64 The Drive
Craigweil
Bognor Regis
PO21 4DT

Objection to Planning Application AW/344/14/HH

With reference to the above application from 68 The Drive we most strongly object on the grounds that the proposed changes will not be in keeping with a conservation area. We additionally wish to make the following points:

EAST ELEVATION - PROPOSED.

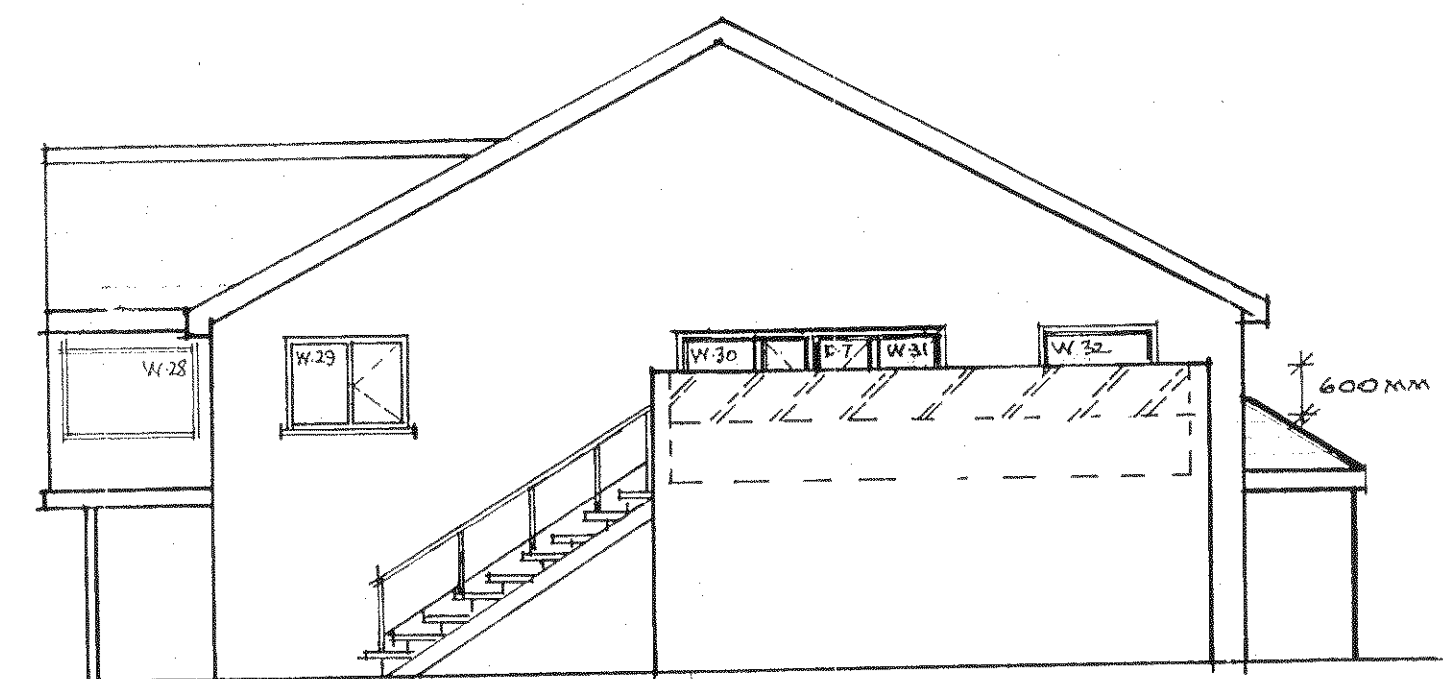
- (1) The new terrace and outside staircase at first floor level on the eastern side is an unacceptable intrusion into the privacy of the residents at 70 The Drive as it overlooks their bedroom and all other south facing windows and garden of their property.
